RiverOak Strategic Partners

Applicant's Cover Letter for Deadline 3 Submissions

TR020002/D3/CL

Project Name:	Manston Airport Development Consent Order
Application Ref:	TR020002
Submission Deadline:	3
Date:	15 February 2019

MANSTON AIRPORT DEVELOPMENT CONSENT ORDER  
ENGINEERING DRAWINGS AND SECTIONS - BUILDING HEIGHT  
REGULATION 5(2)(o)  
THANET DISTRICT COUNCIL

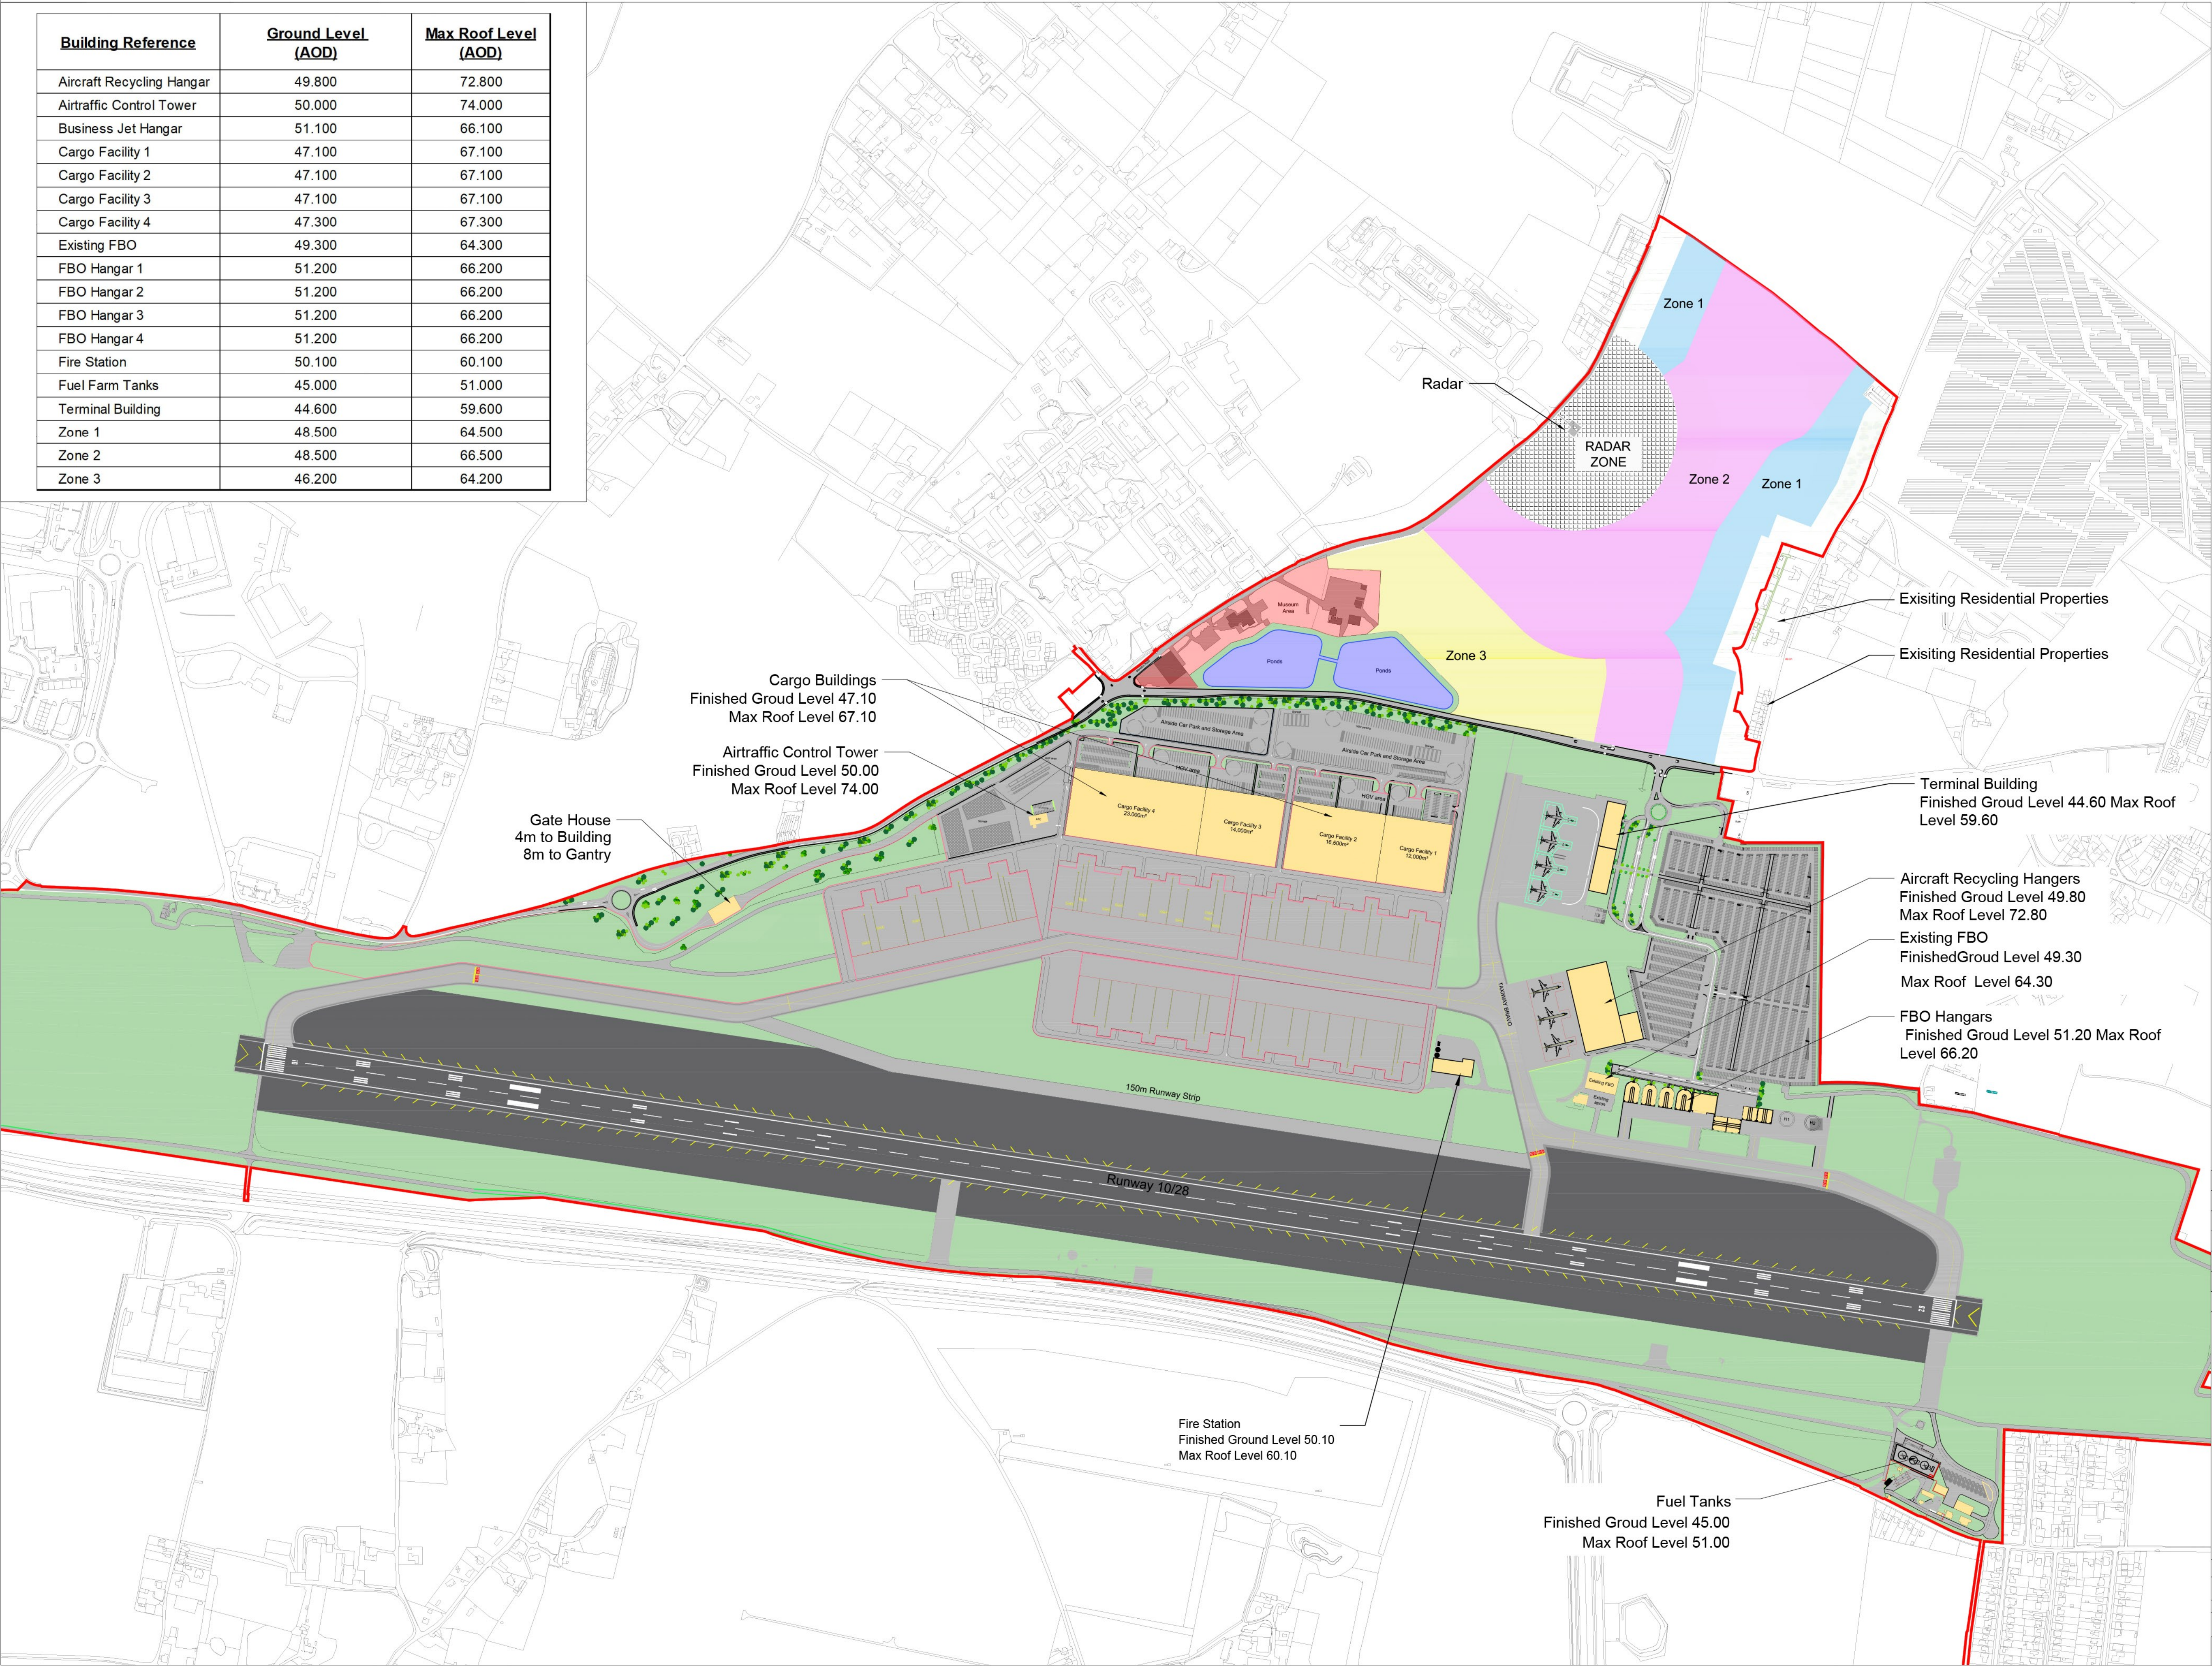
1.1 Sheet 8/18

In the table in the top left hand corner of the sheet, the figure listed for The *Ground Level (AOD)* for the *Airtraffic Control Tower* should be **47.000**.

1.2 Sheet 8/18

In the sheet key under Zone 3 Σ *Building GFA - $\leq 28,000m^2$ of B8 development* should read as
 *Σ Building GFA - **$\leq 26,000m^2$** of B8 development*
